Subject: 2024/CL/91331/W - Meltham Town Council Response

Our planning committee have noted this application with the following comments:

Garden Room as Proposed

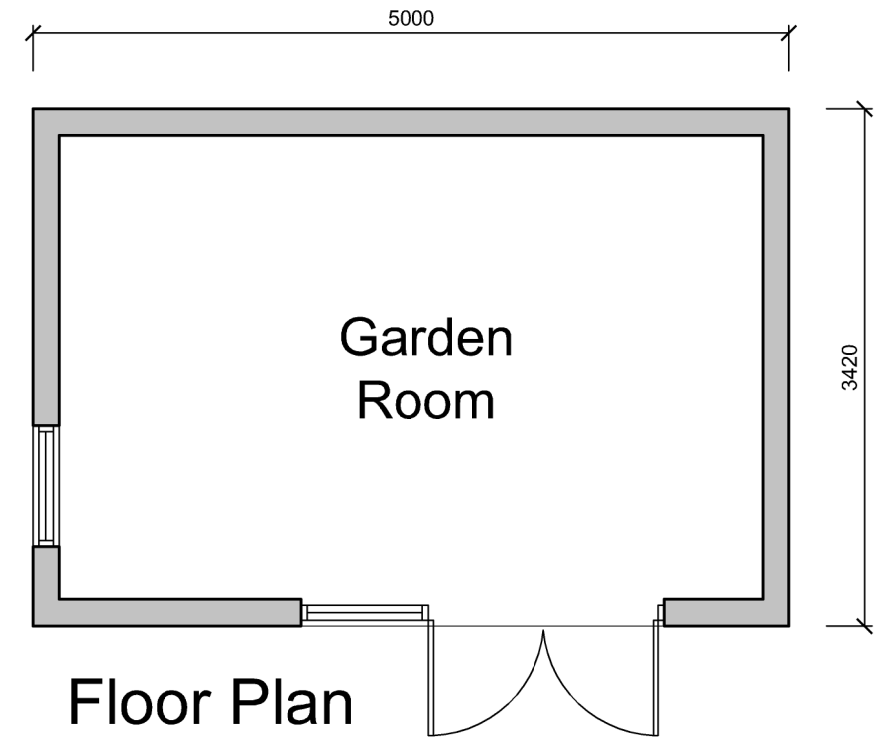
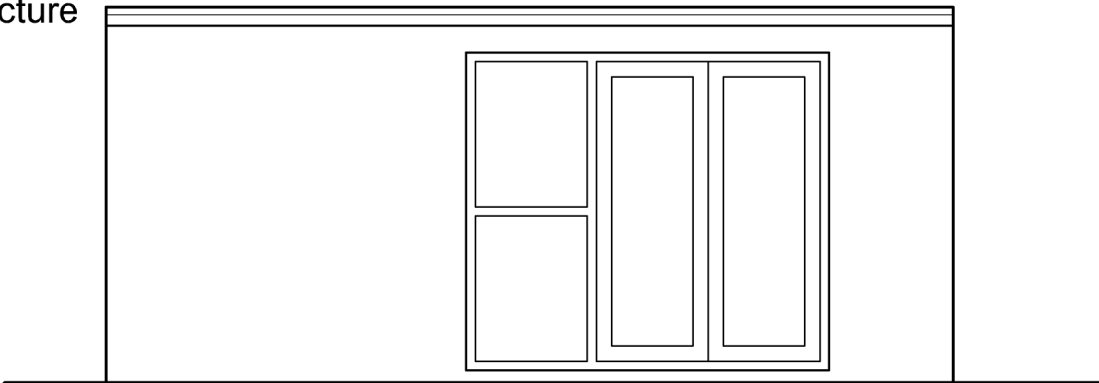
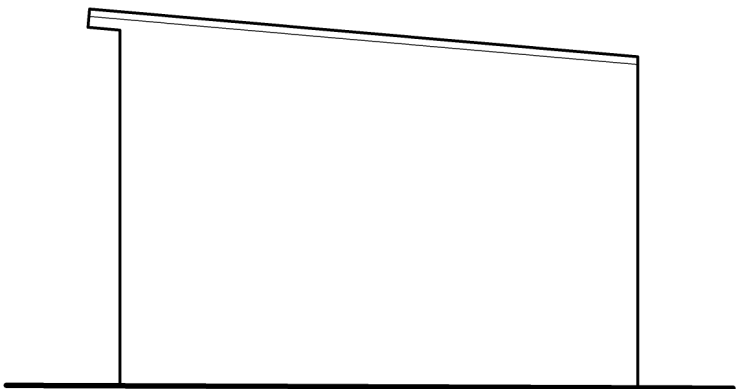
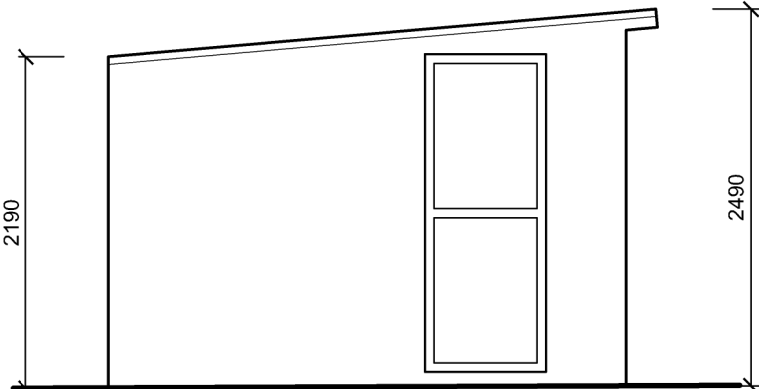
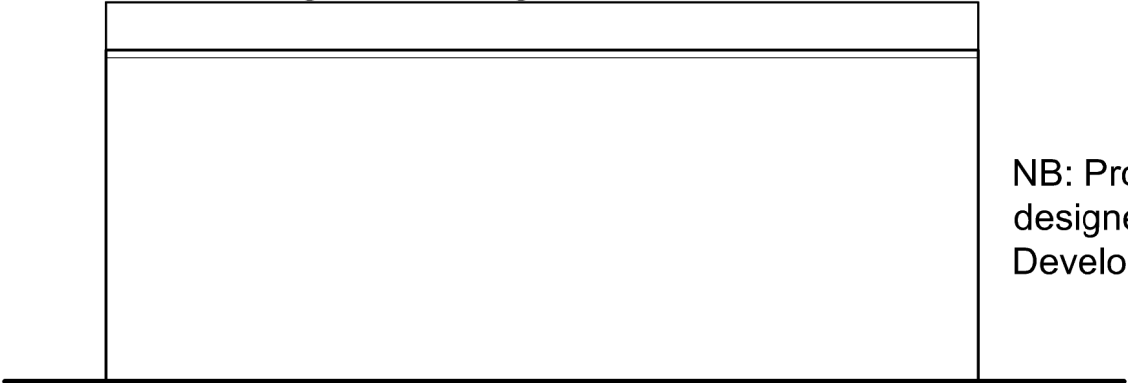
The size of room stated for a garden room/office seems a little excessive.
Concern with the roofline and it looking out of balance with the adjoining property.
